City of Albuquerque

Public Works Department Transportation Development Services Section

January 8, 2001

Re: Traffic Circulation Layout (TCL) Submittal for Building Permit Approval for
Rastra NM Plant, [B13 / D20]
4485 Irving Blvd. NW
Architect's Stamp Dated 1/07/02

sheet title
As-Built Site Plan

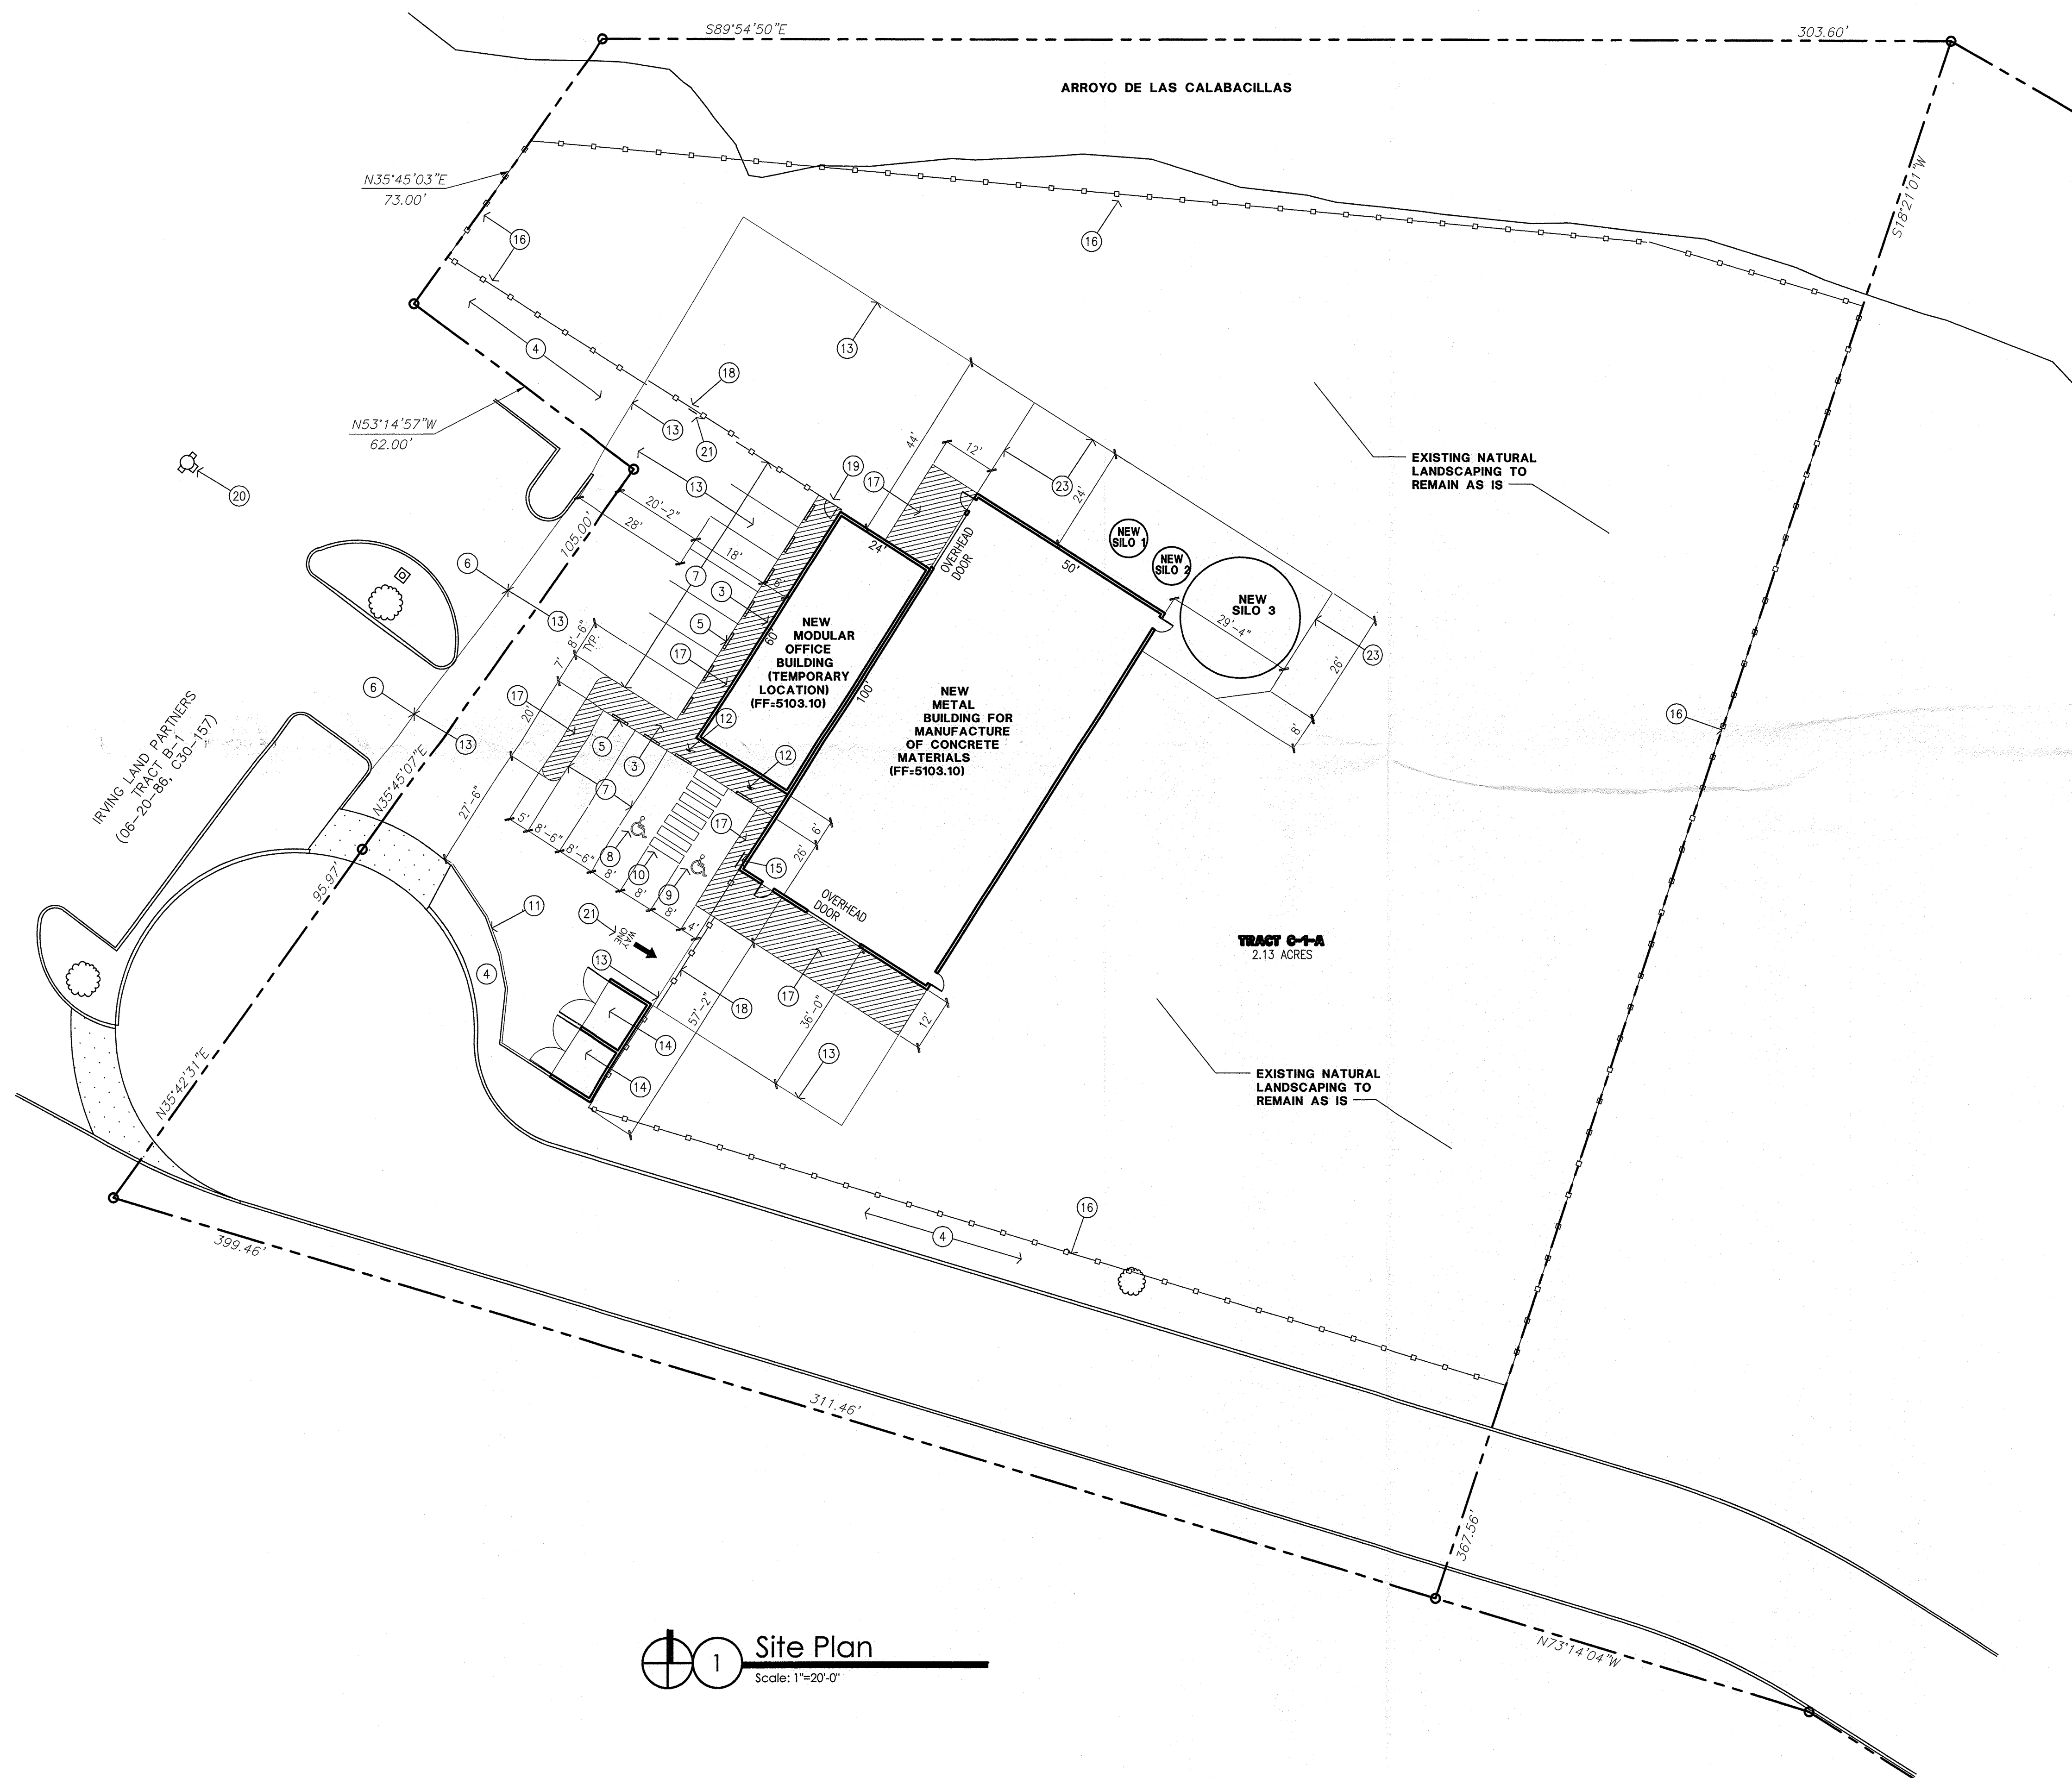
The TCL submittal, dated 1/08/02, is approved for acceptance by this office and is stamped and signed as such in condition that you place bollards in appropriate setting in the east side of the building near the door entries. Four copies will be required: two for submittal of building permit plans, one for this office and one to be kept by you to be used for certification of the site for final C.O. for Hydrology/Transportation.
